Department of Transportation

October 7, 2020

SH 21
El Paso County

RE: Security Fire Station 4 Site Development Plan | Security Fire Protection District
EA18135 | Site Development Plan

# SITE DEVELOPMENT PLAN

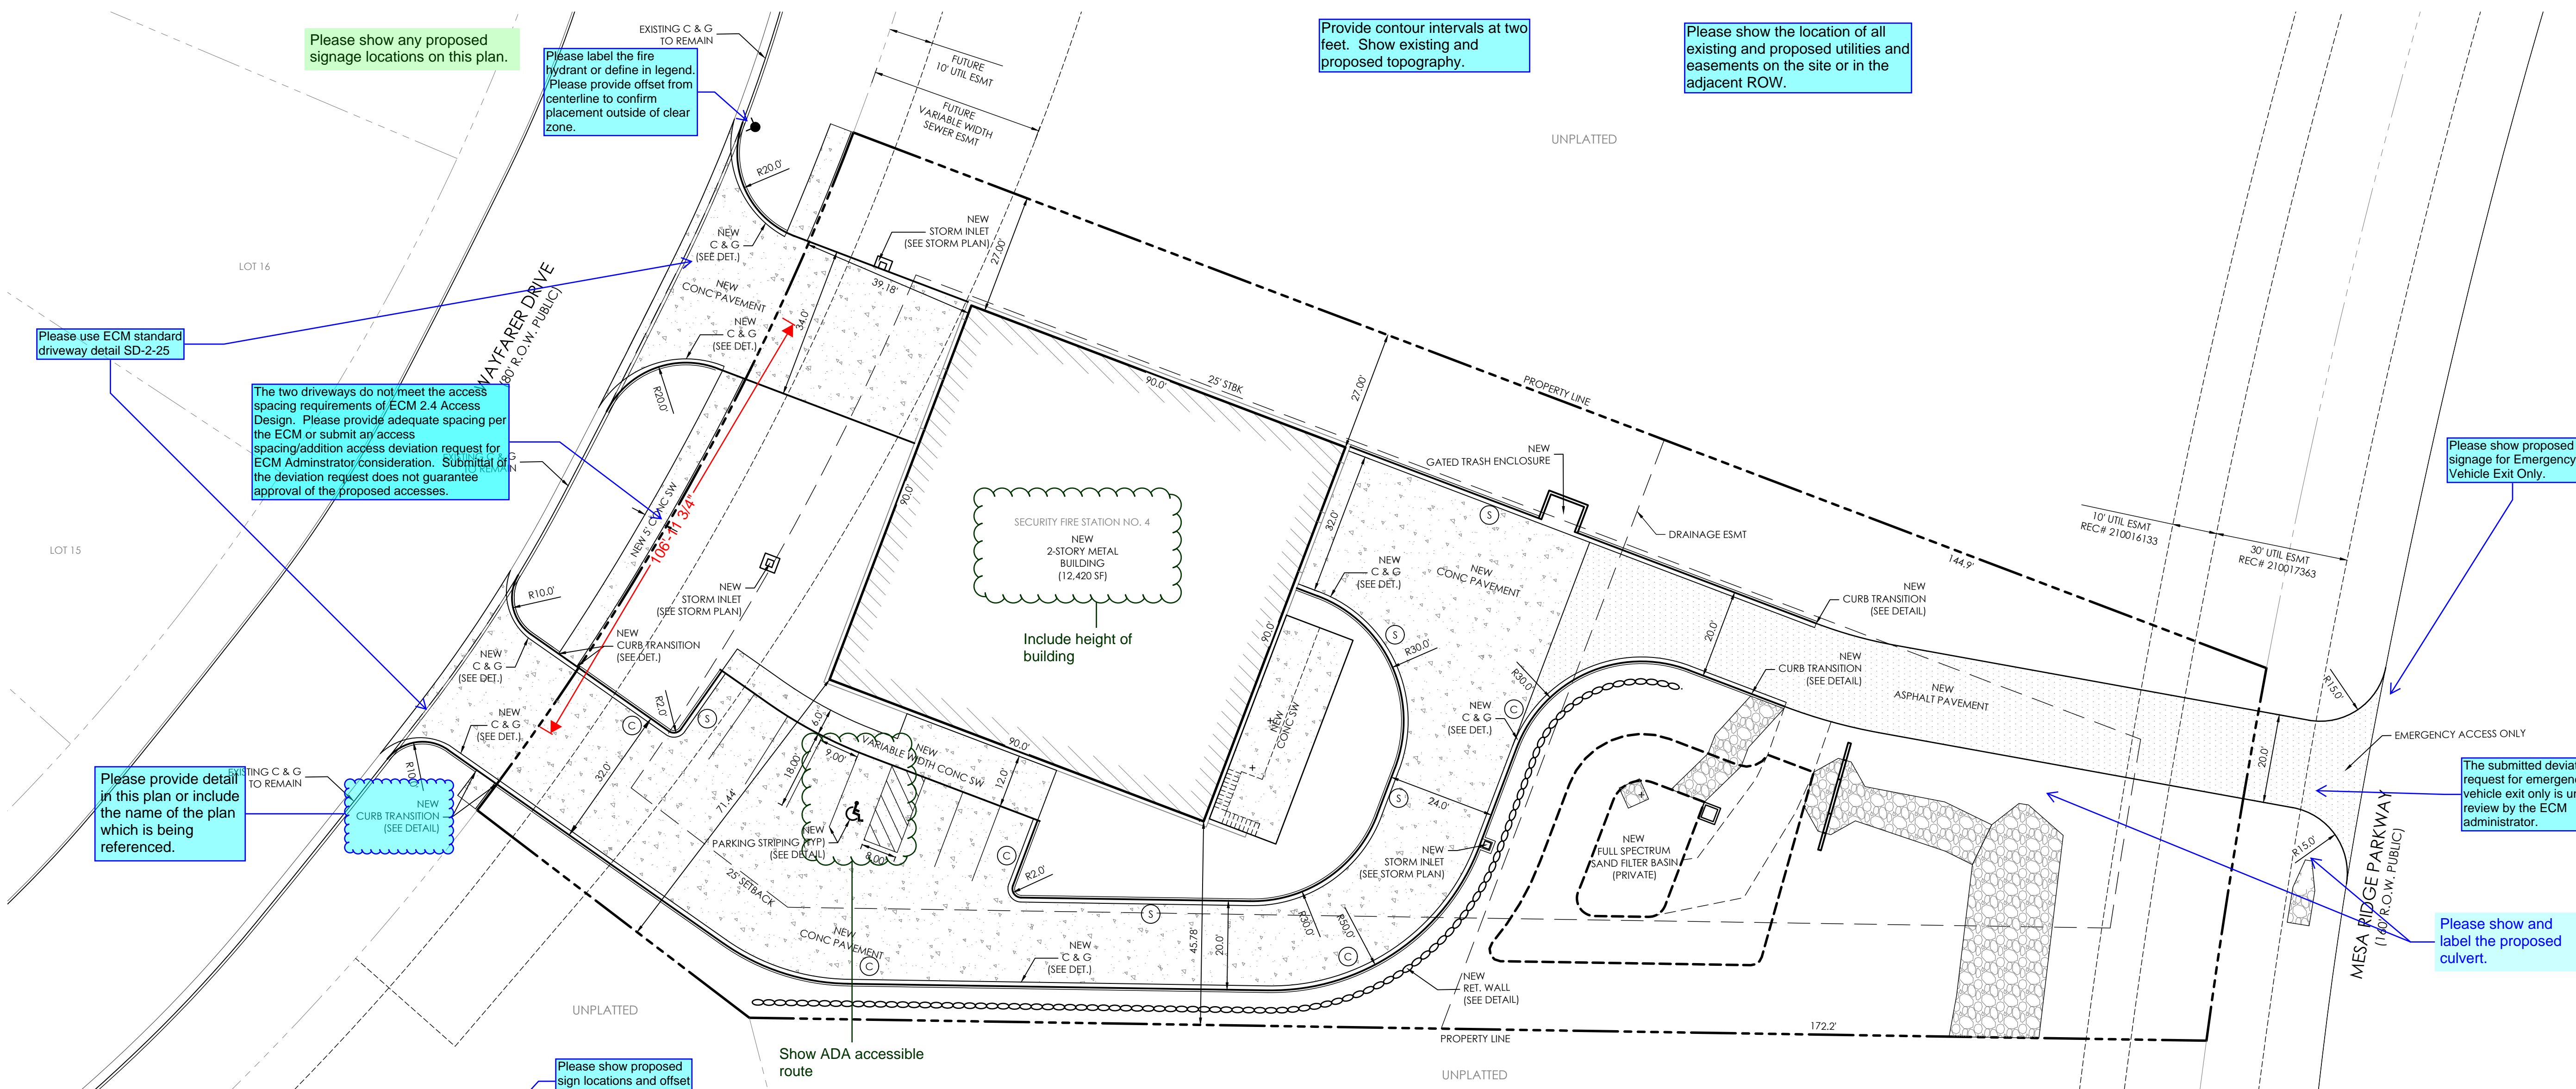
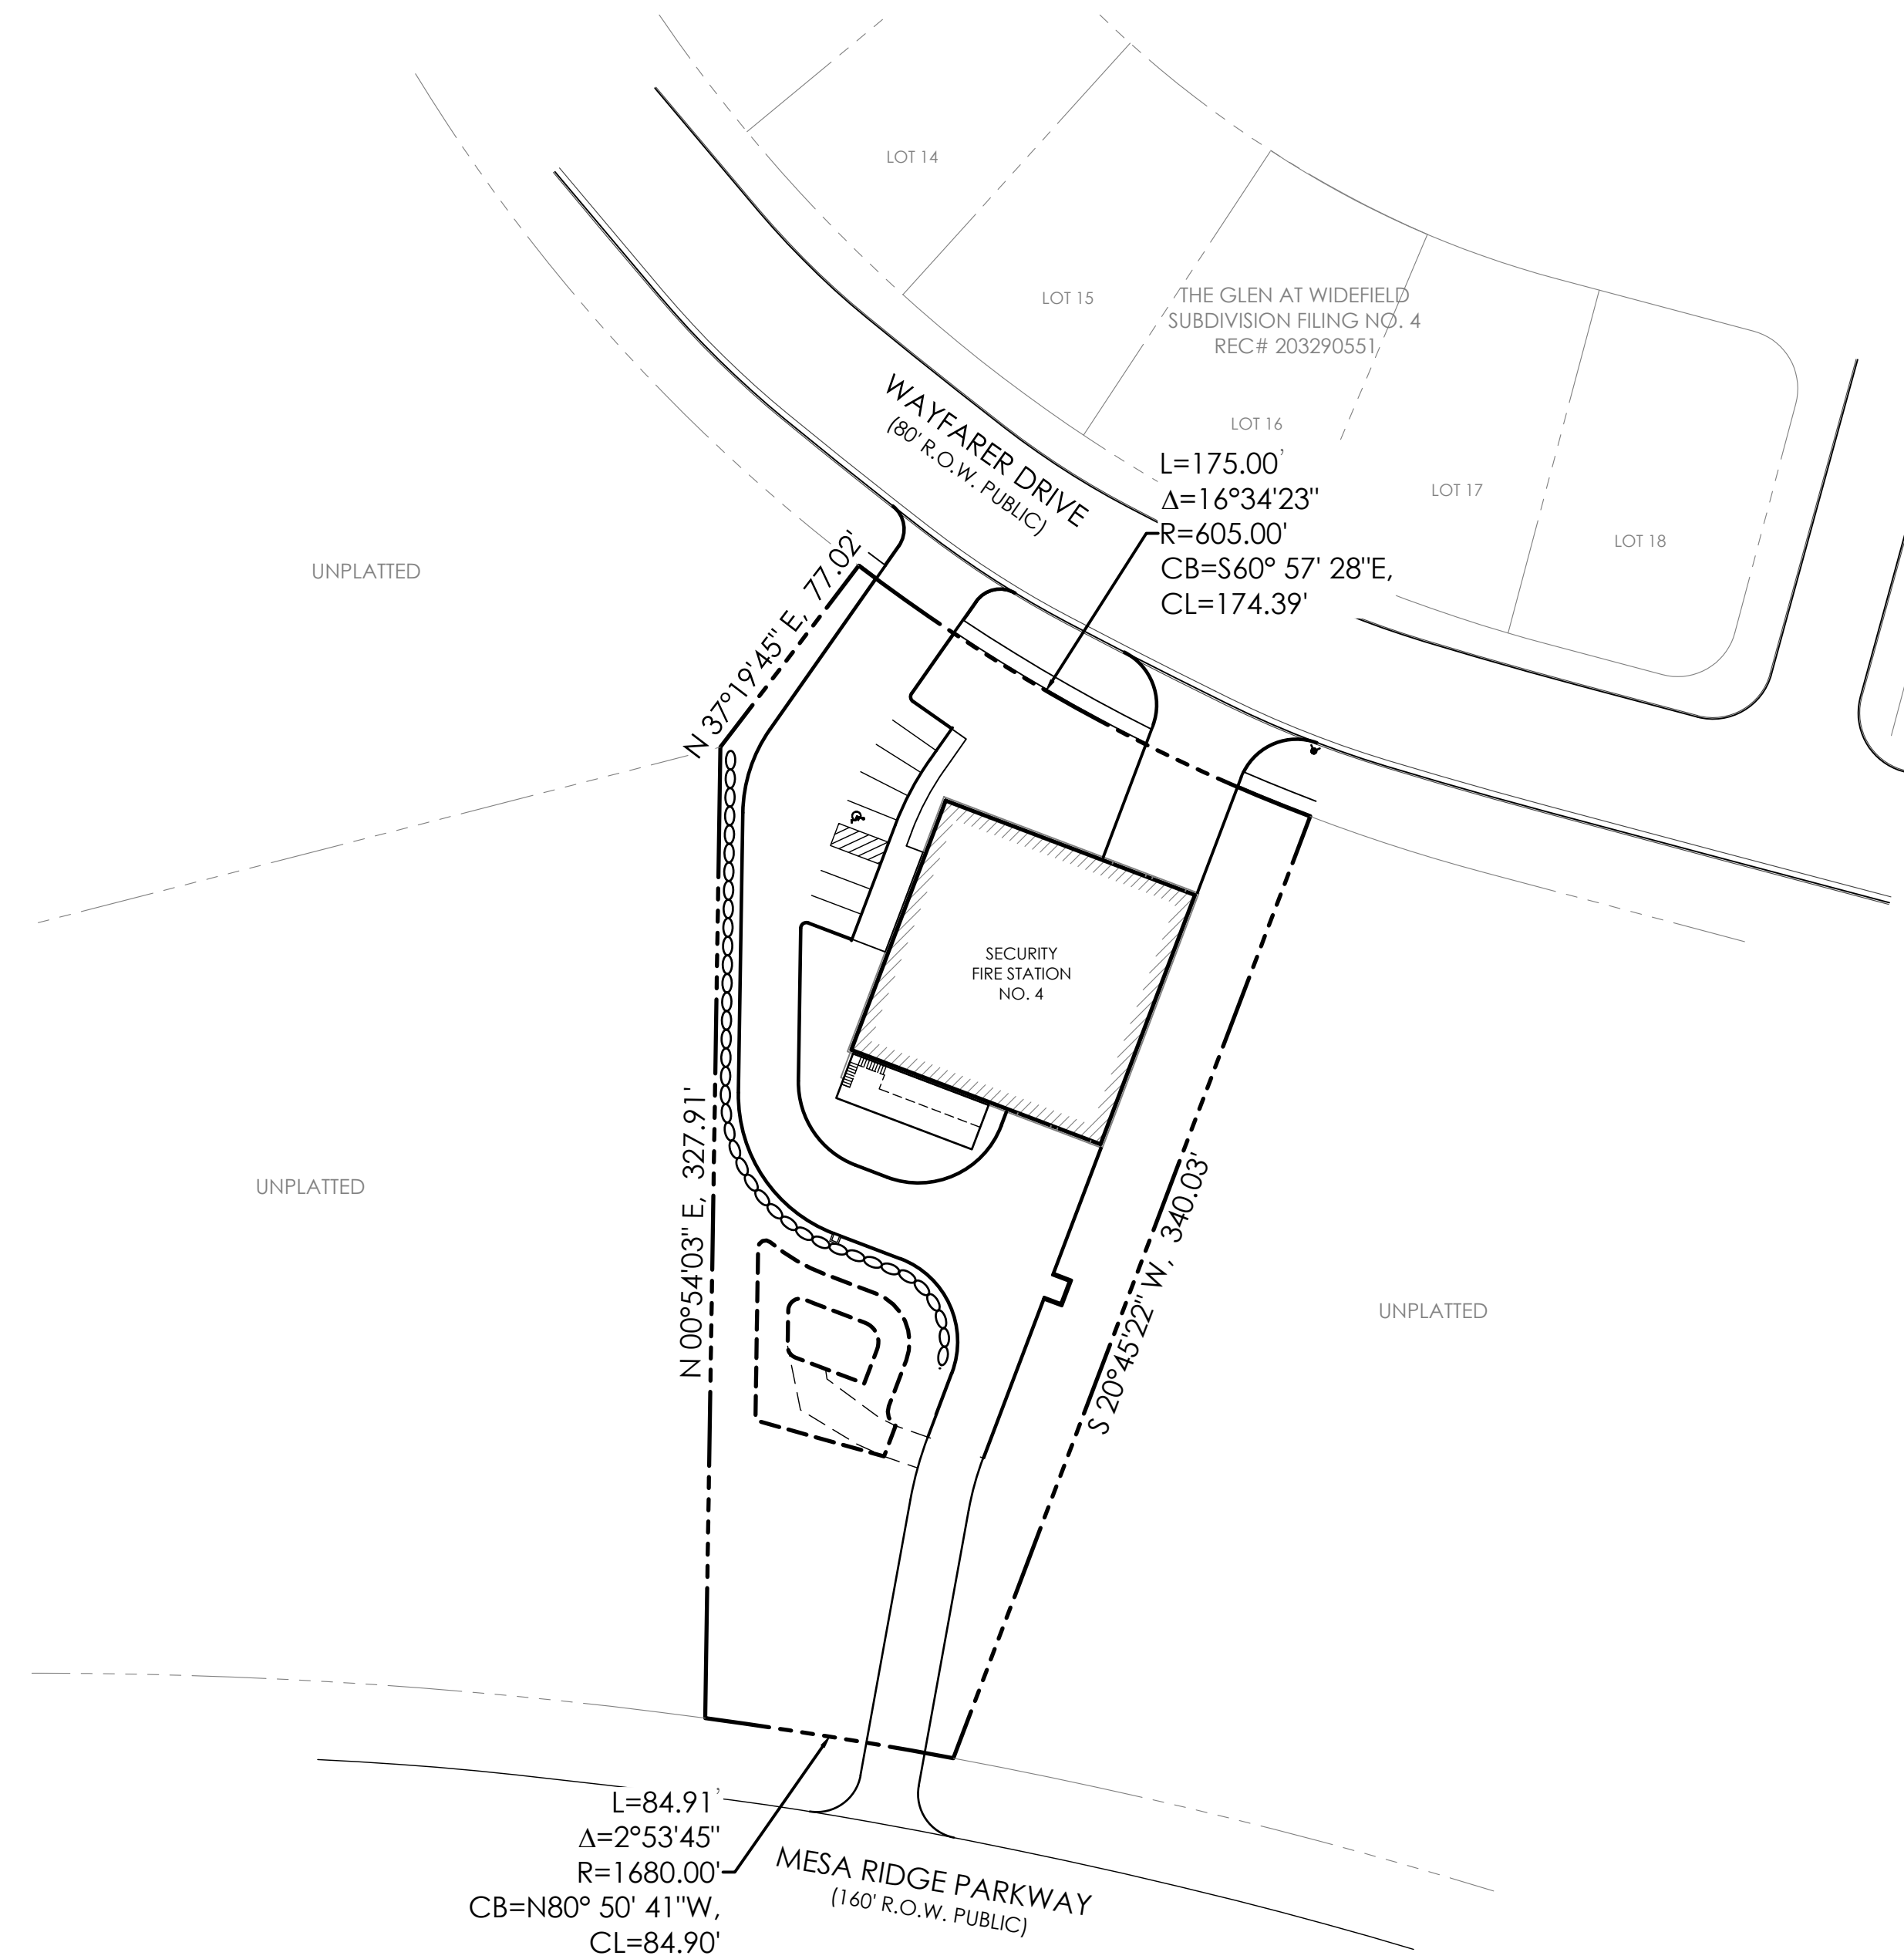
- Based on the location and expected minimal traffic volume CDOT will NOT require an access permit at this time.
- How will you ensure that the traveling public and non-emergency traffic will not make the Mesa Ridge Parkway access a thoroughfare?
- No access will be granted along the category F-W (Interstate System, Freeway Facility) State Highway 21 (Powers Blvd) now or in the future for any purposed improvements to the property without Federal Highway Administration approval.
